Application no: 21/02177/DISC

Location: : Proposed Roundabout Access To Graven Hill And Wretchwick Green,
London Road, Bicester

Transport Development Control

Objection to discharge of condition

B. Phase of Works & Vehicle Routing Plan

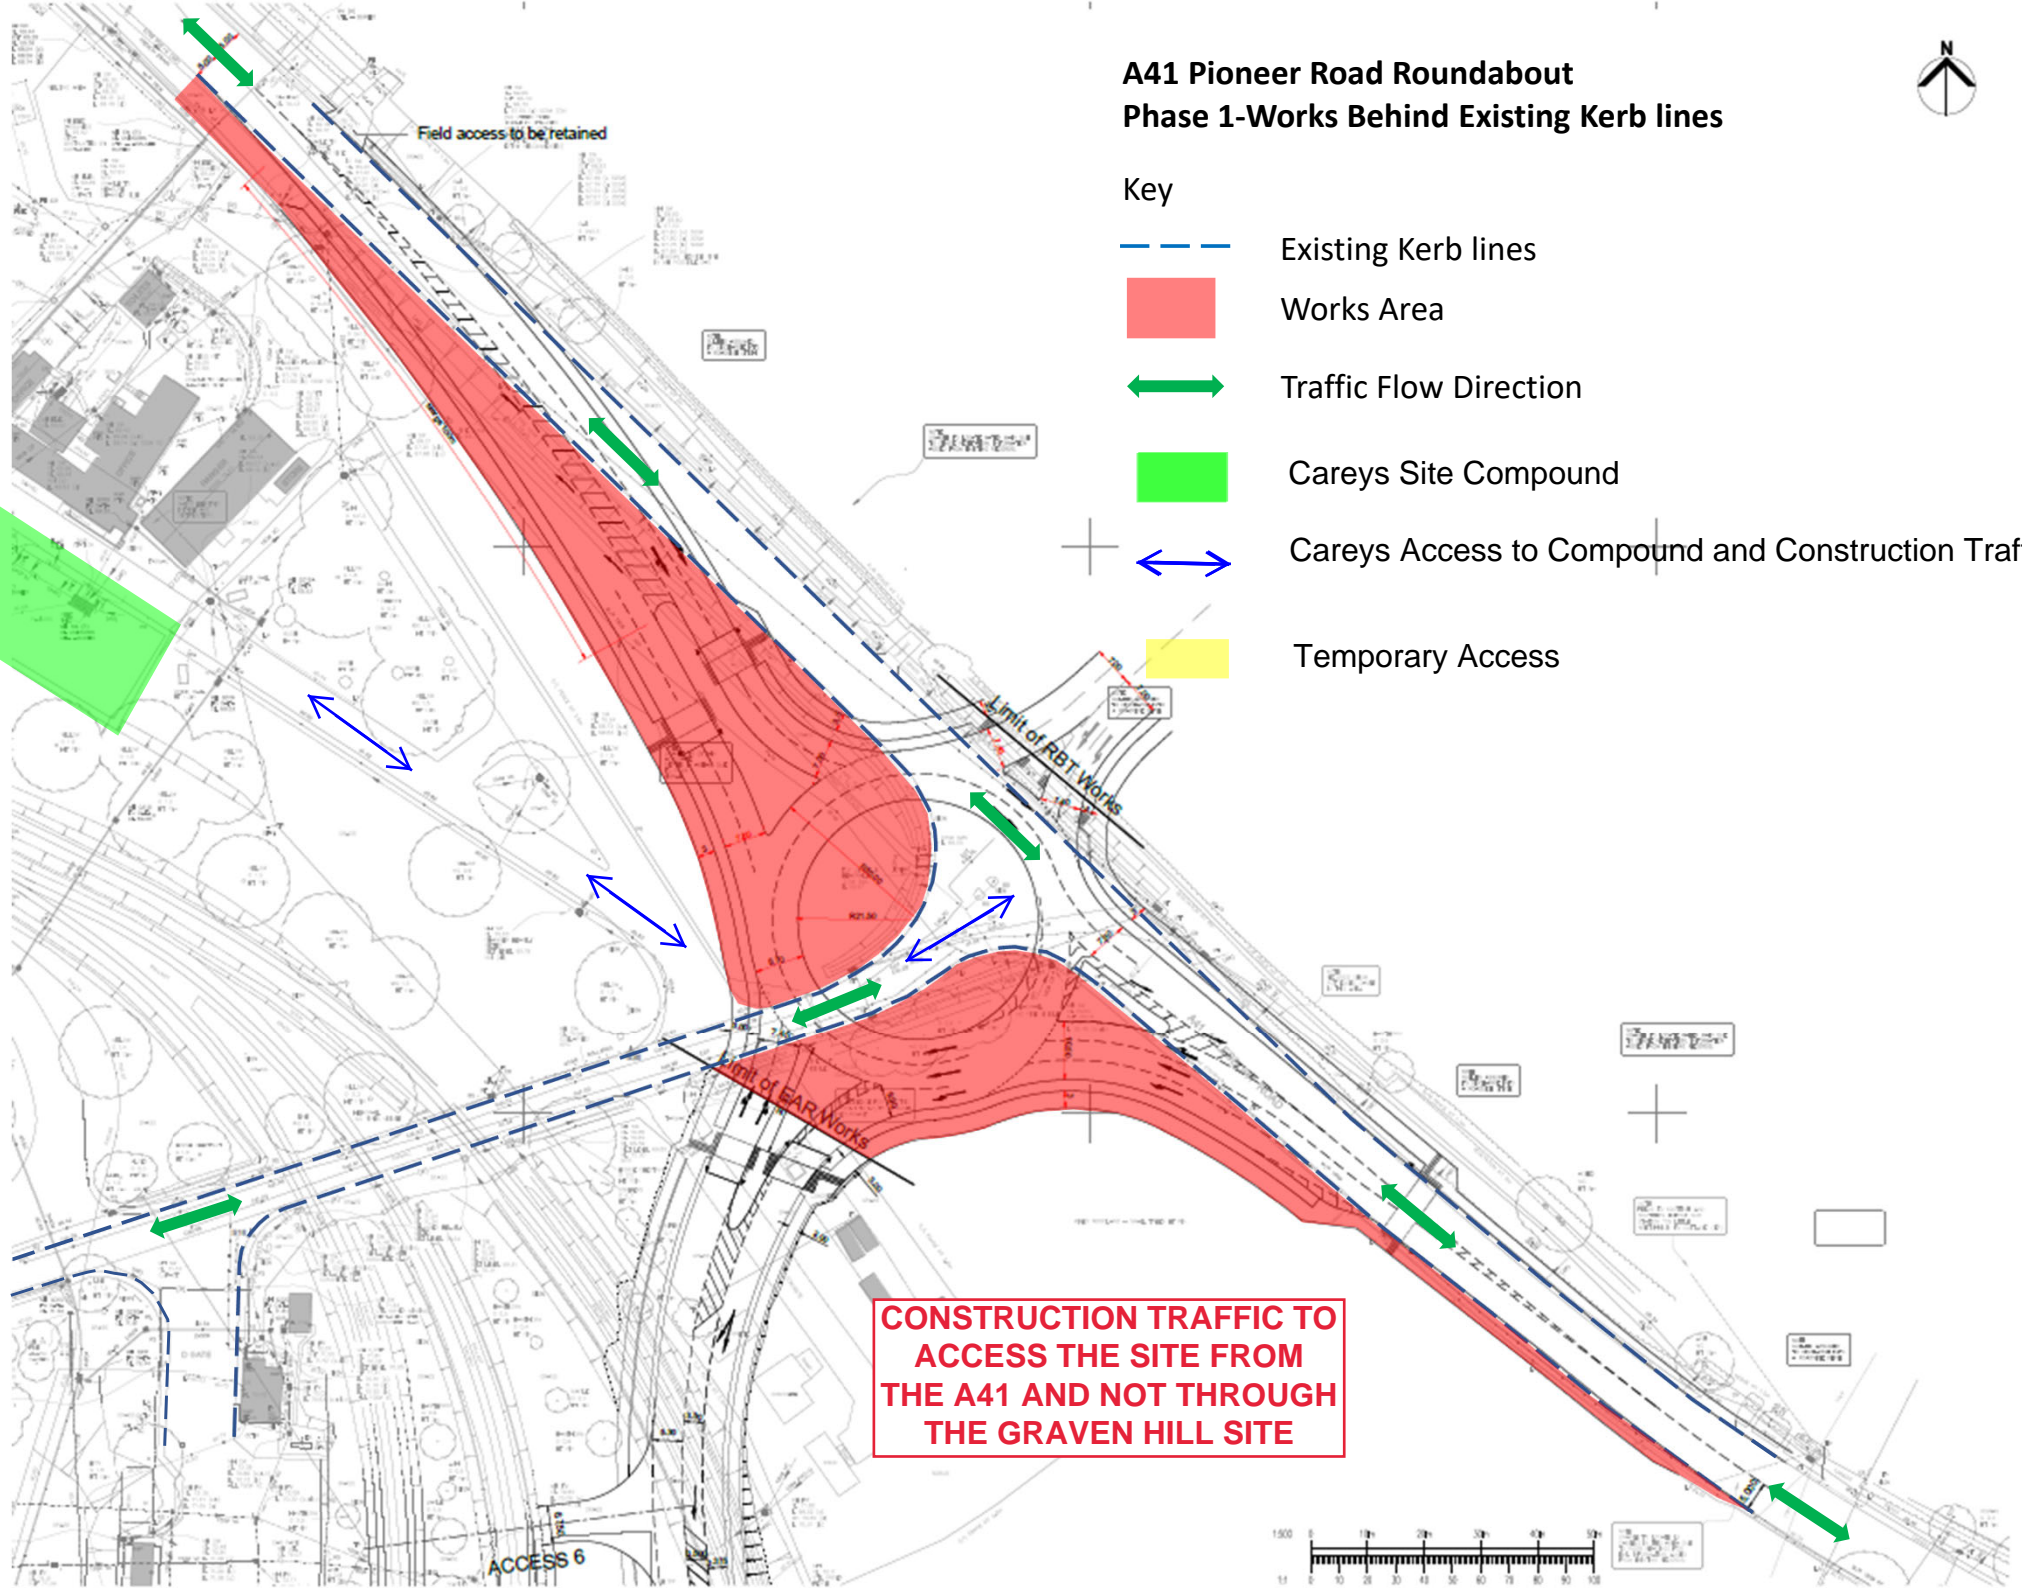
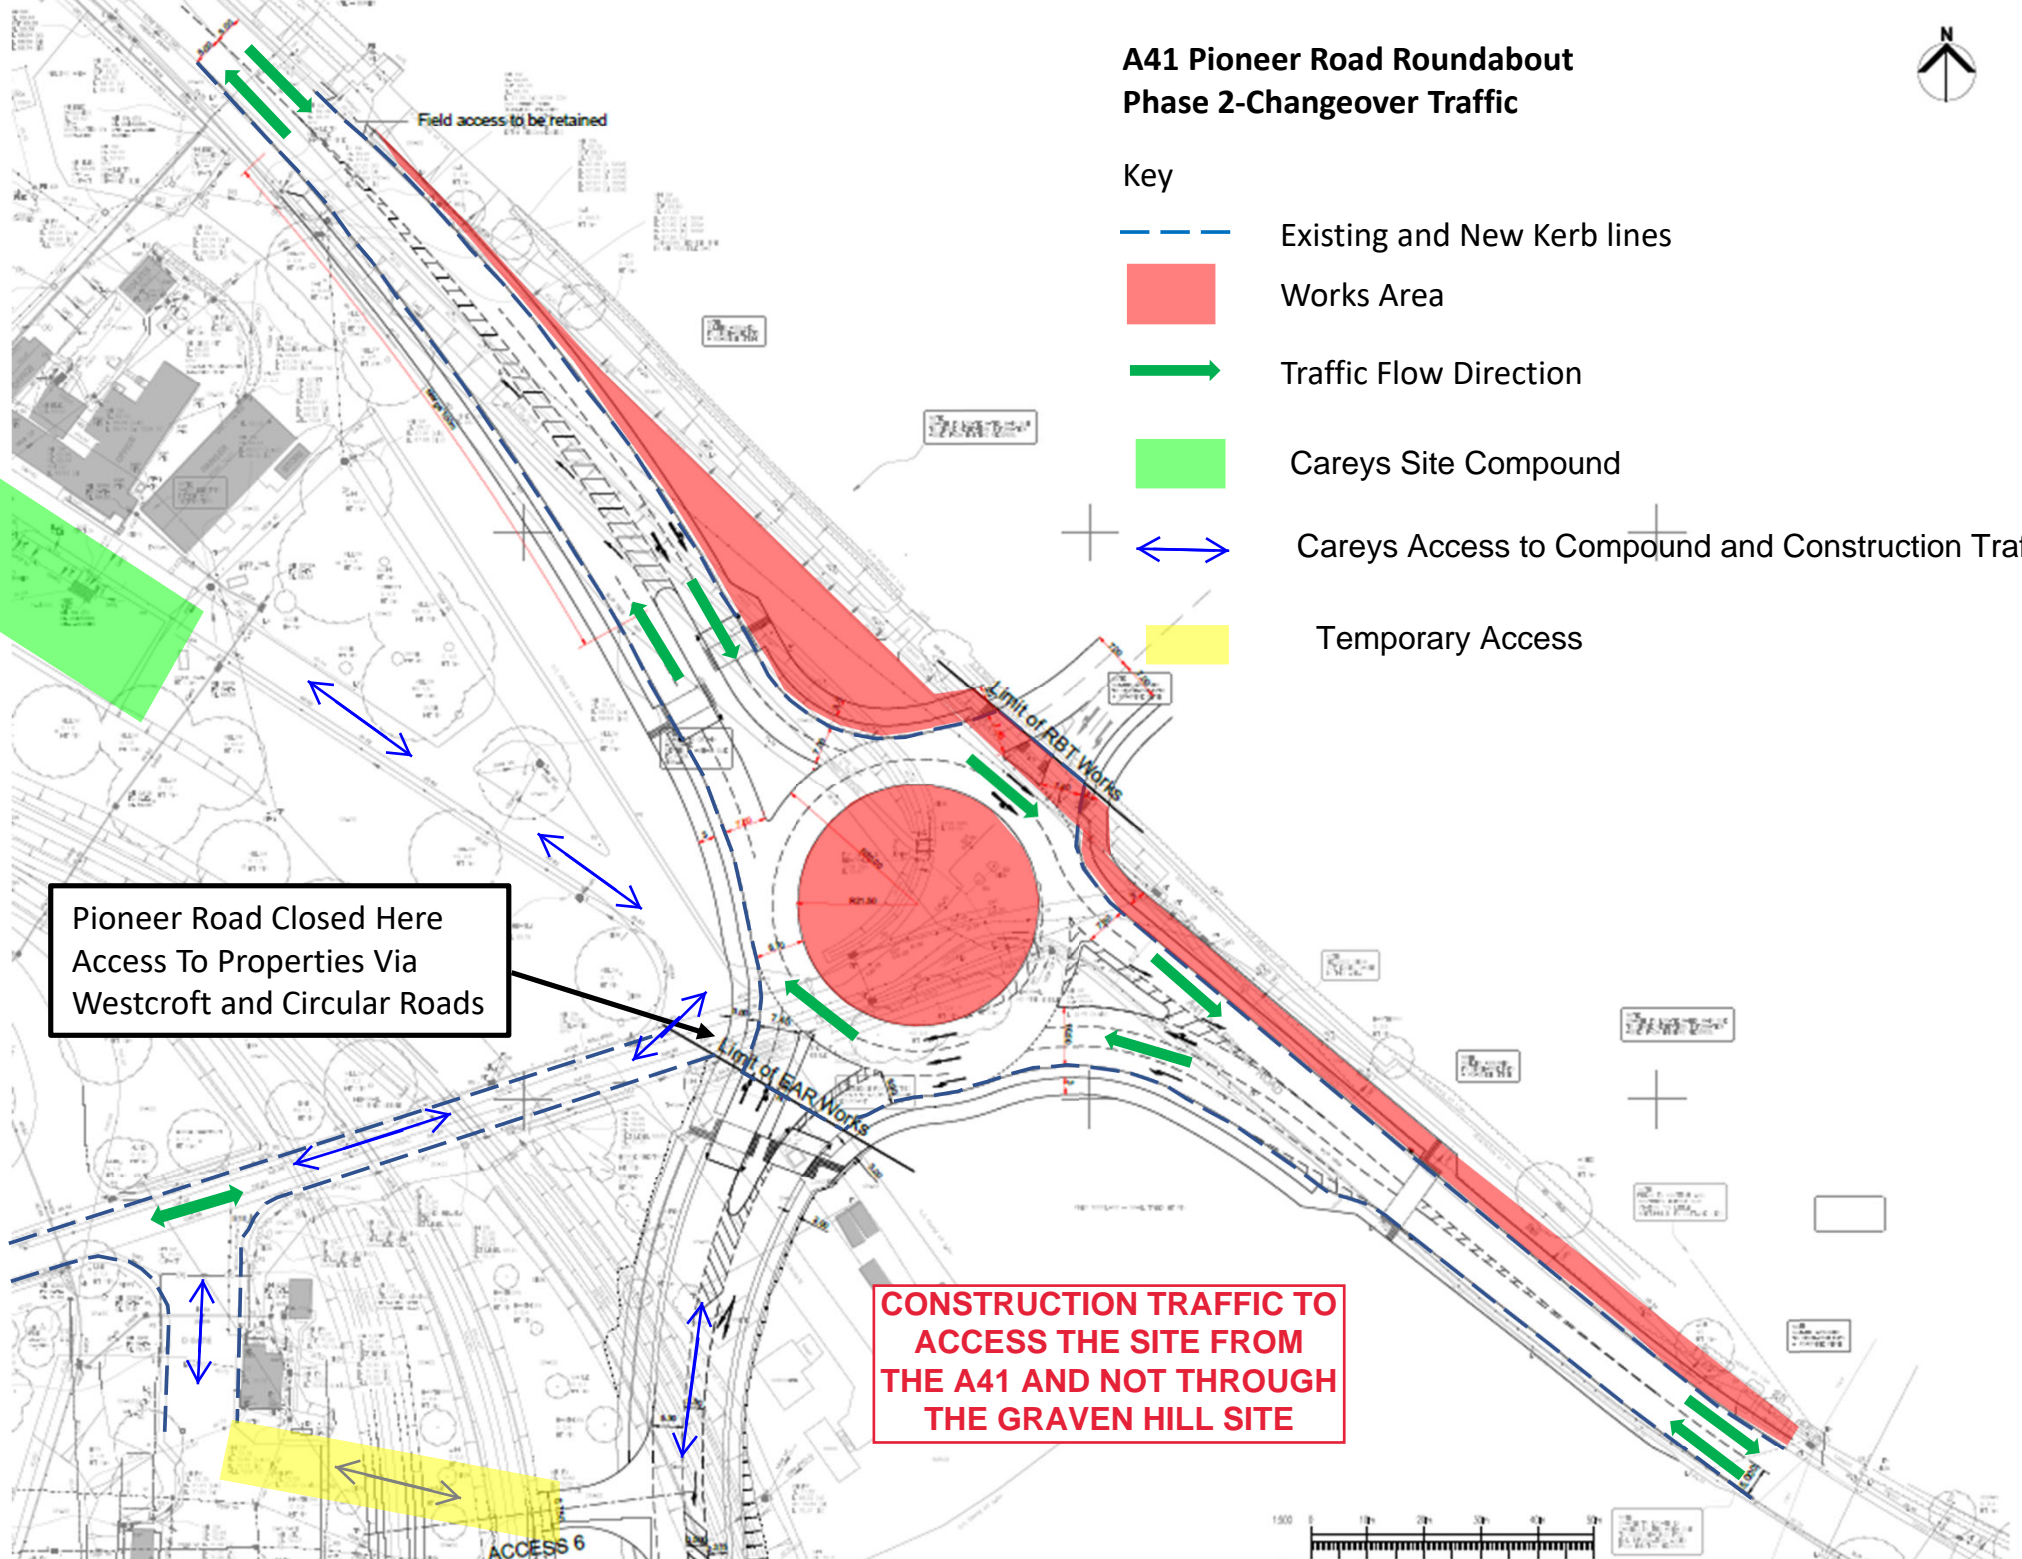
- No information is given on the access route to the site for construction traffic. I would expect this to avoid existing residential roads, including within Graven Hill.
- Insufficient information is given regarding the diversion of pedestrian and cycle routes, however, this would be subject to the agreement with the Highway Authority in connection with licenses issued for the works.
